October 19, 2023

Comments on the Fowler Creek Guest Ranch SEPA Environmental Checklist

PROPOSED EMERGENCY INGRESS & EGRESS PLAN MAP - FOWLER CREEK GUEST RANCH

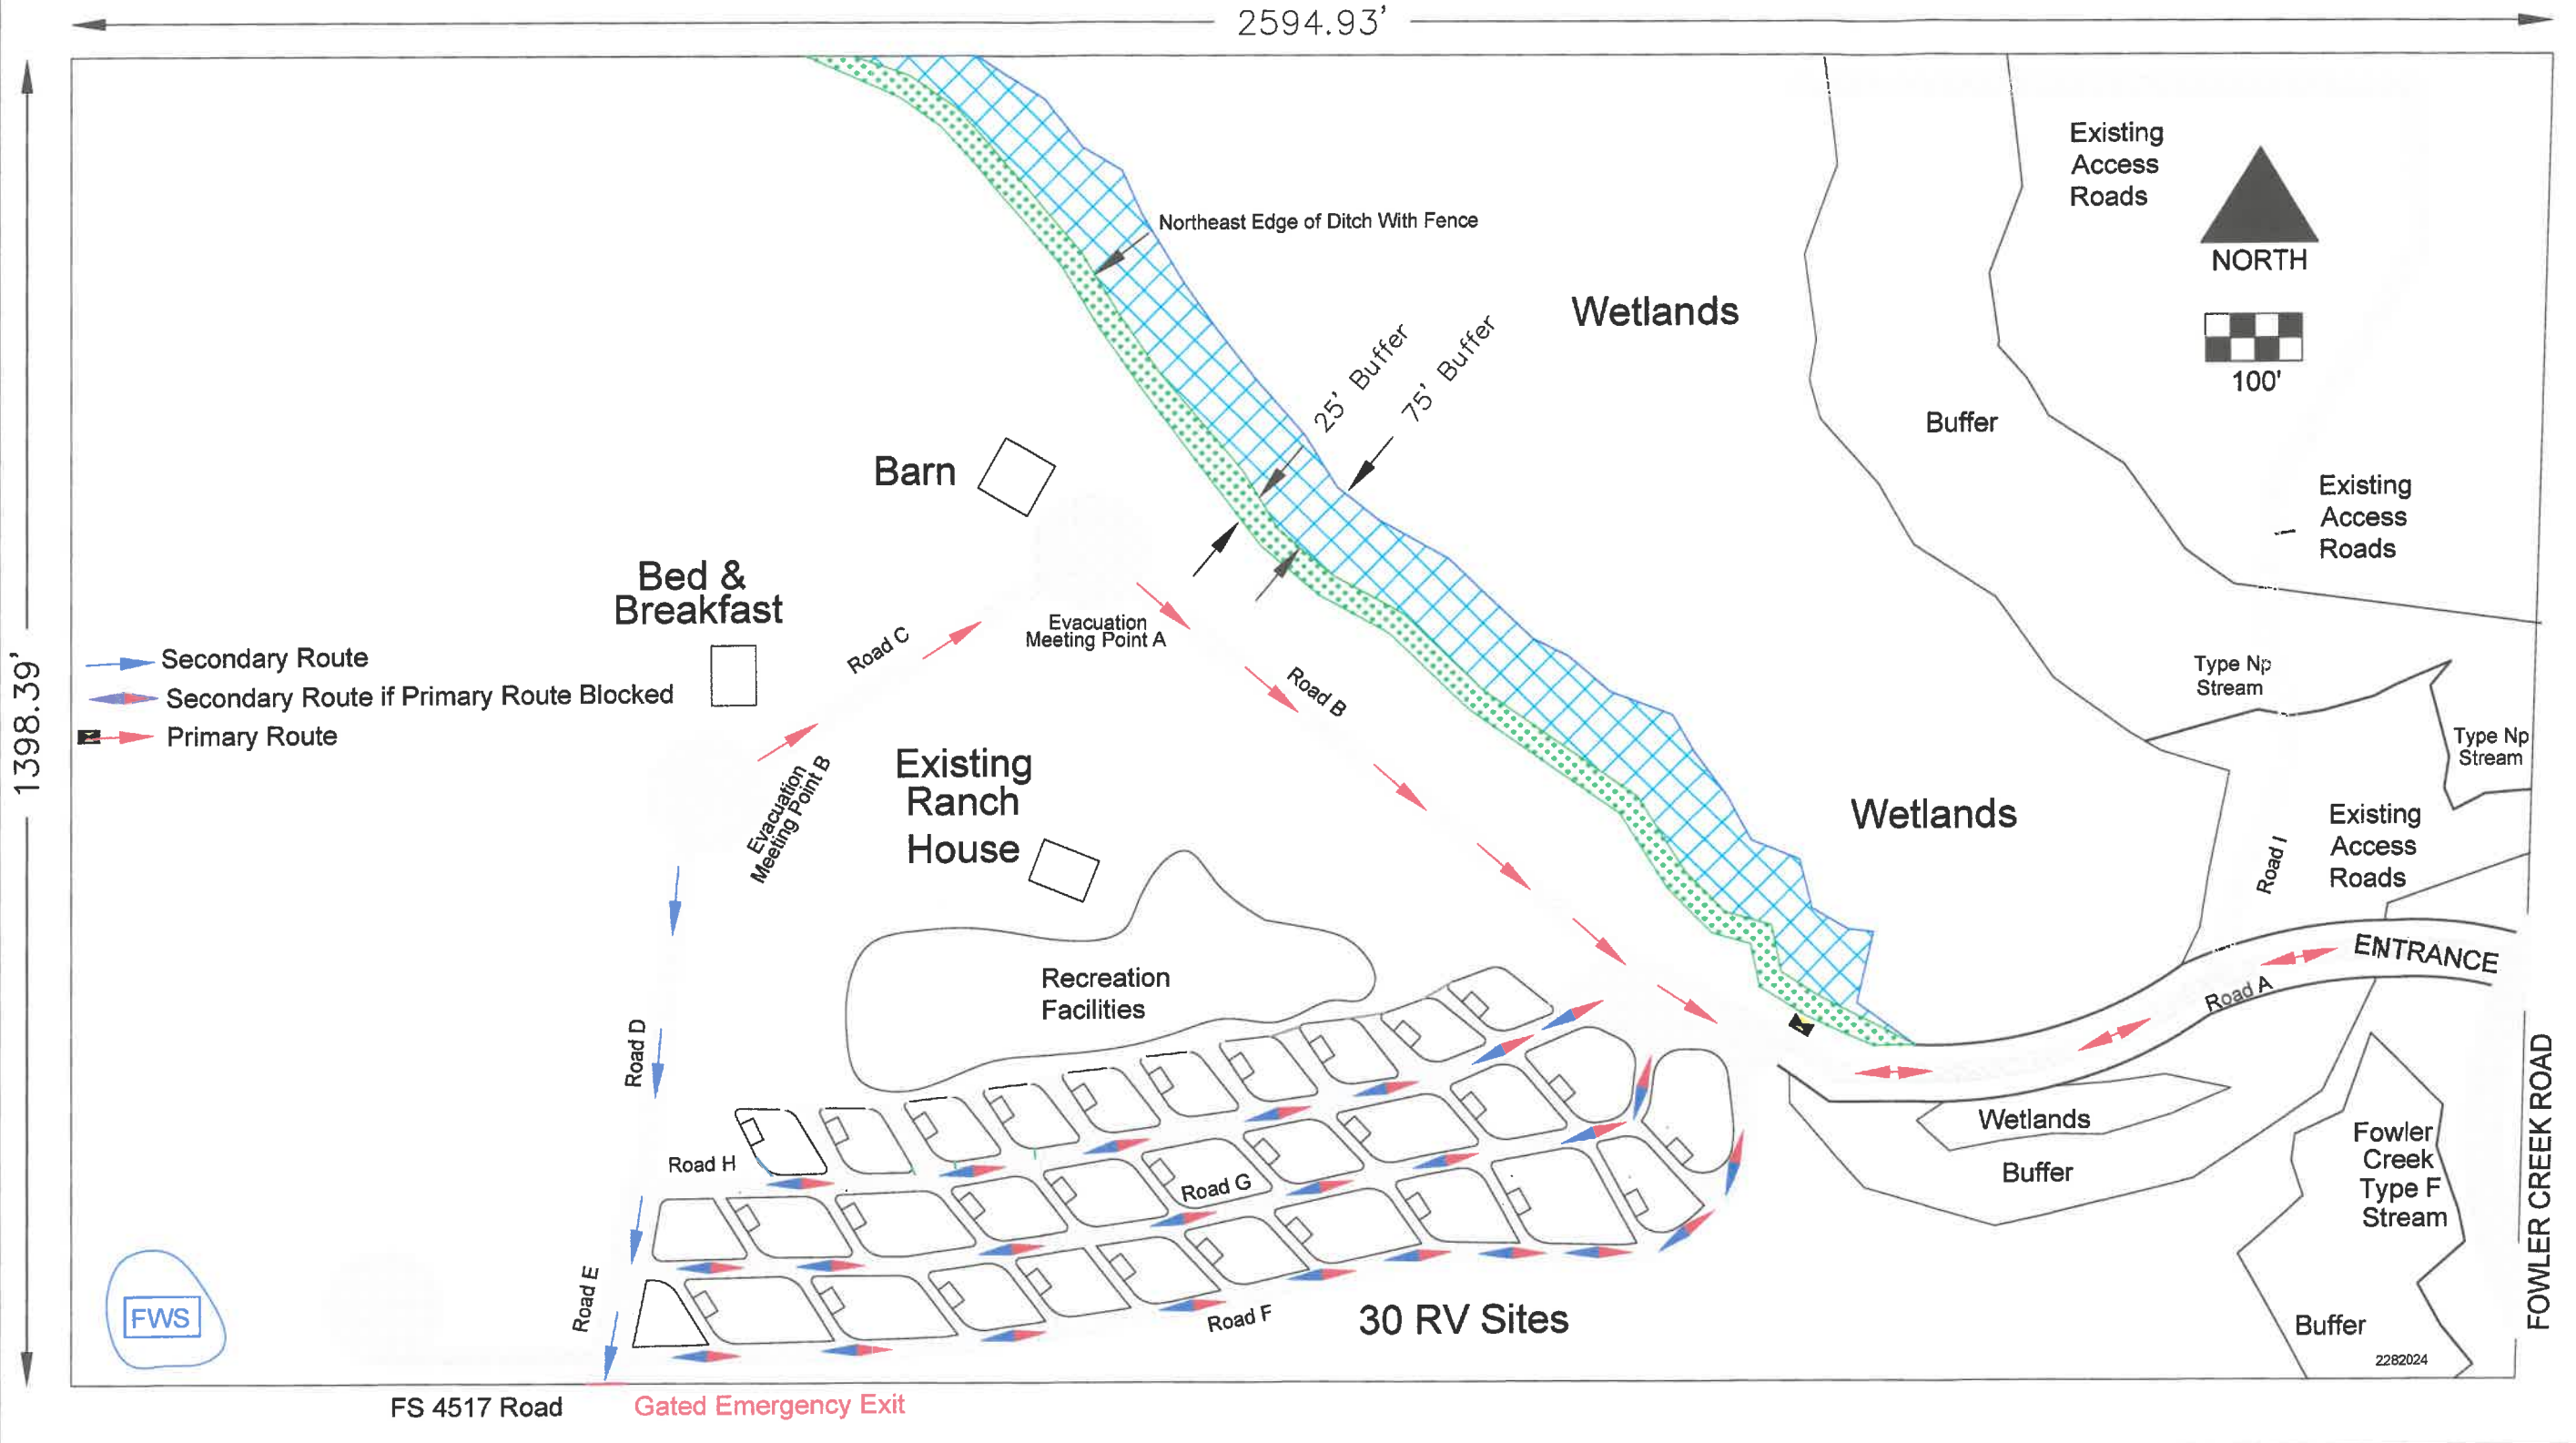
Item 7.a.4 Environmental Health: Emergency Services if needed, may not be available from Fire District 7 and other first responders. Fowler Creek Road and FS Rd 4517 are the only roads in and out for residents and this development. A traffic jam, or accident on the road would prevent access to the site. A wildfire, for example if generated by one of the RV campers cooking outdoors, would spread quickly in dry conditions and could engulf the only roads going in and out. This is an unacceptable safety risk.

SEWAGE MANAGMENT SITE PLAN MAP - FOWLER CREEK GUEST RANCH

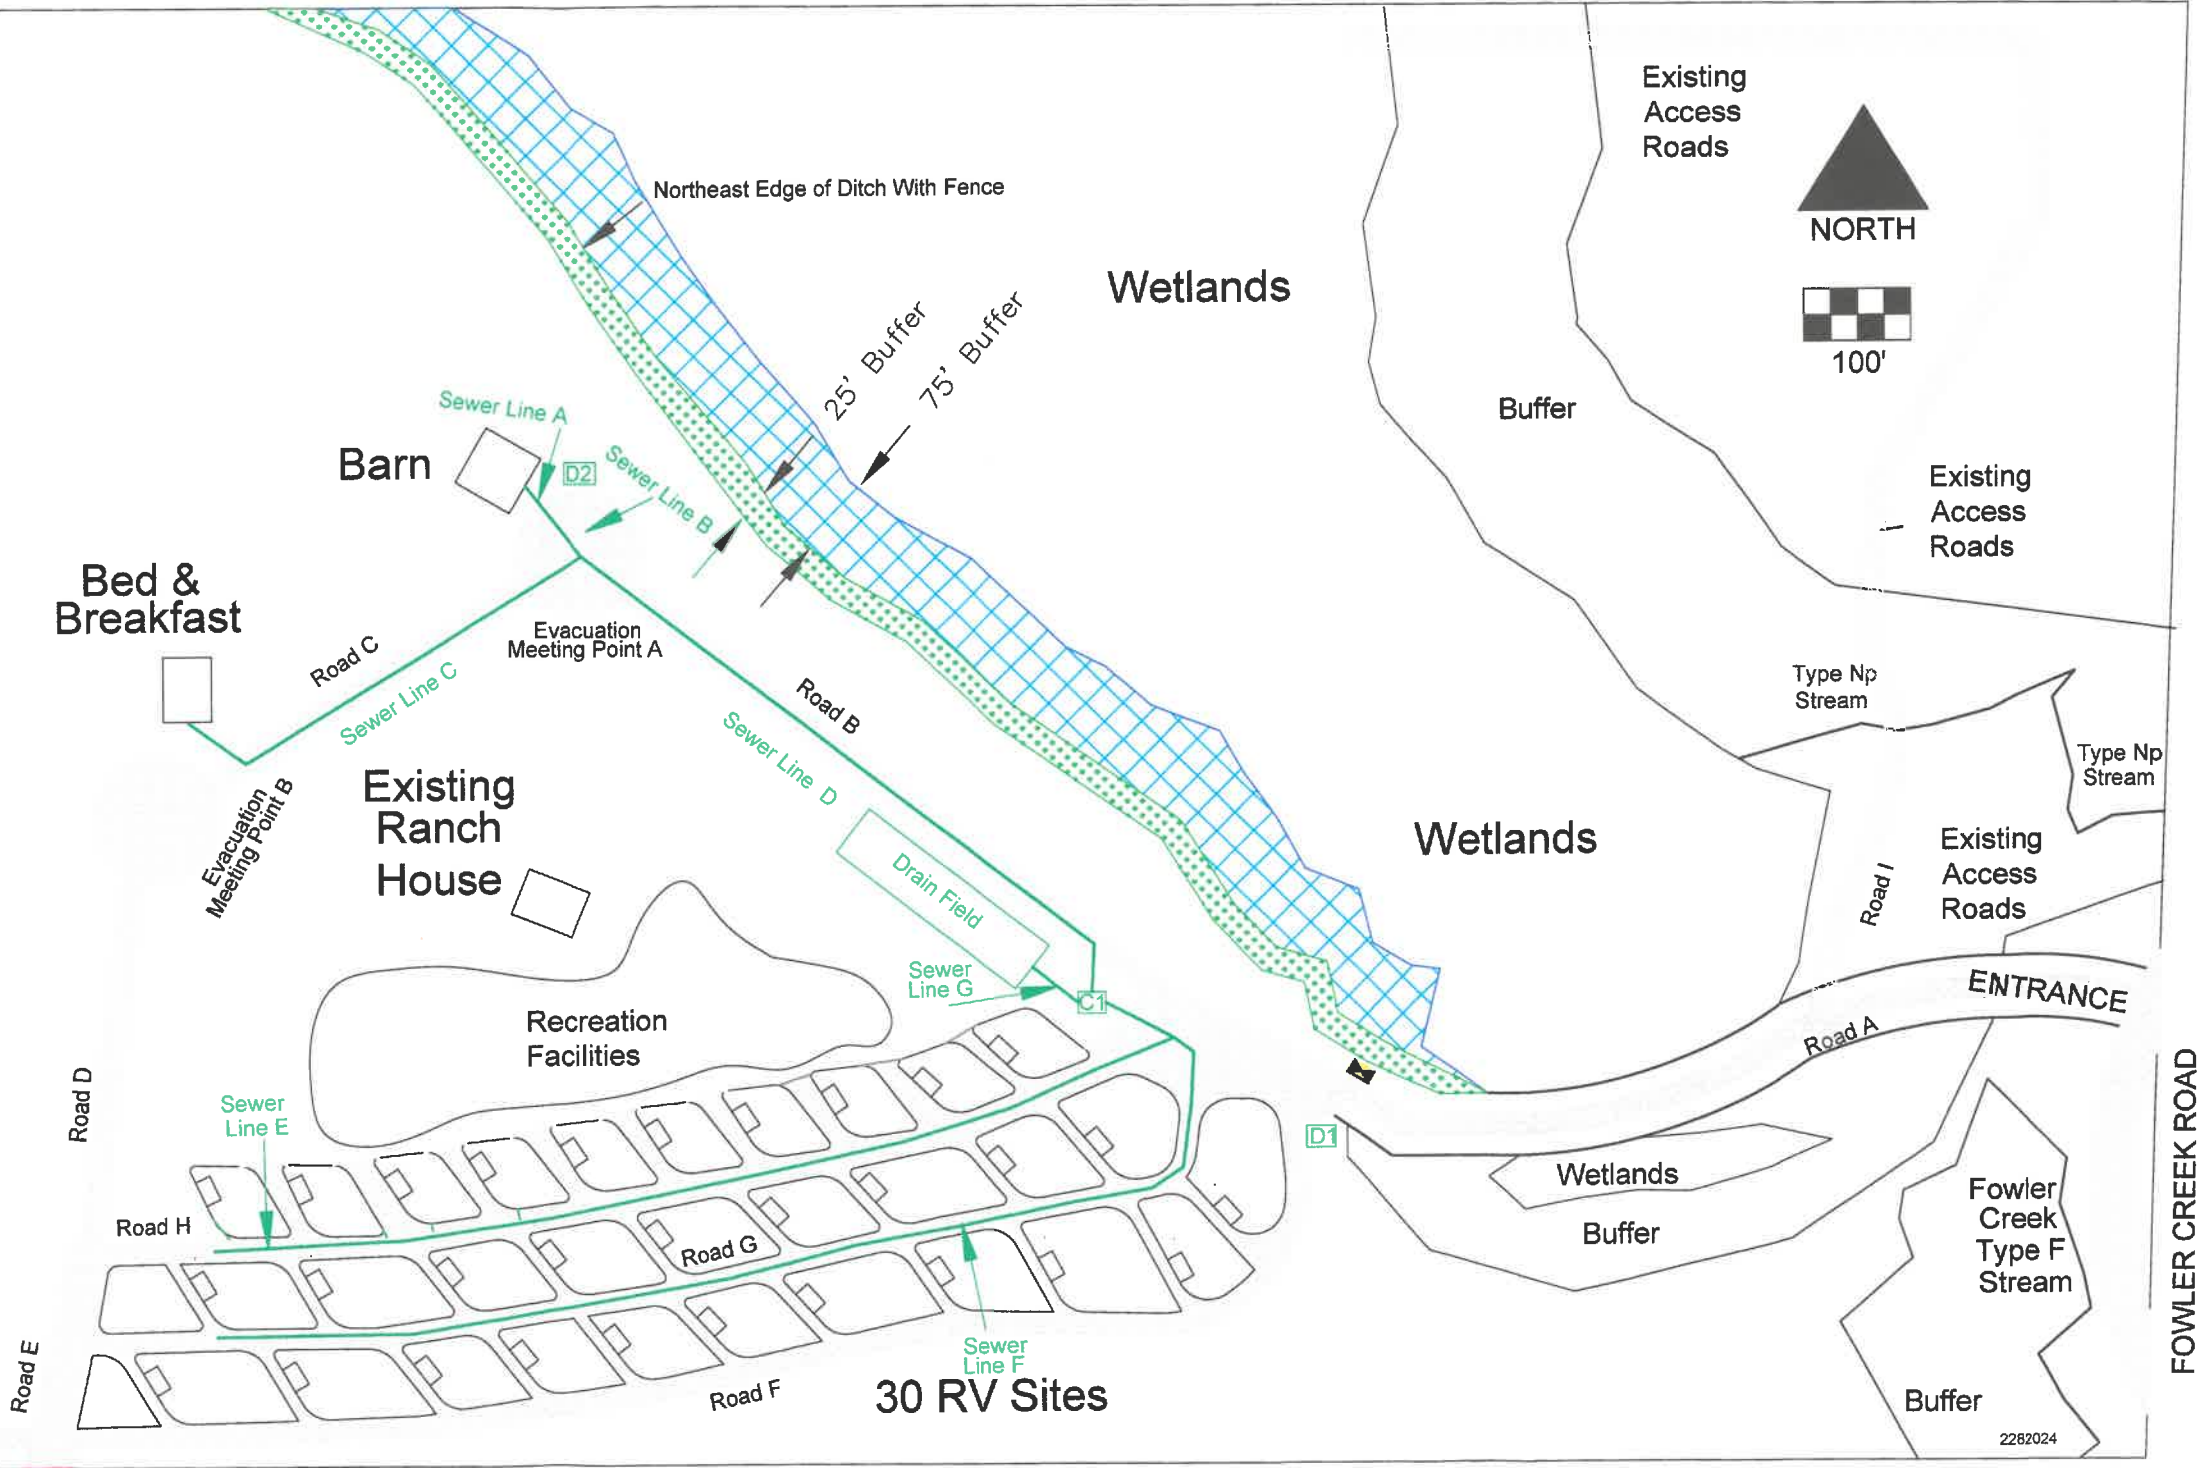
Item 3.b.2 Waste Material: The quantities they showed in Exhibit 9 Sewage Treatment Plan are extremely low. See my estimate in previously submitted comments on Estimated Quantities. The risk of sewage contaminating wetlands and streams may be higher with such a volume, depending on how it is handled.
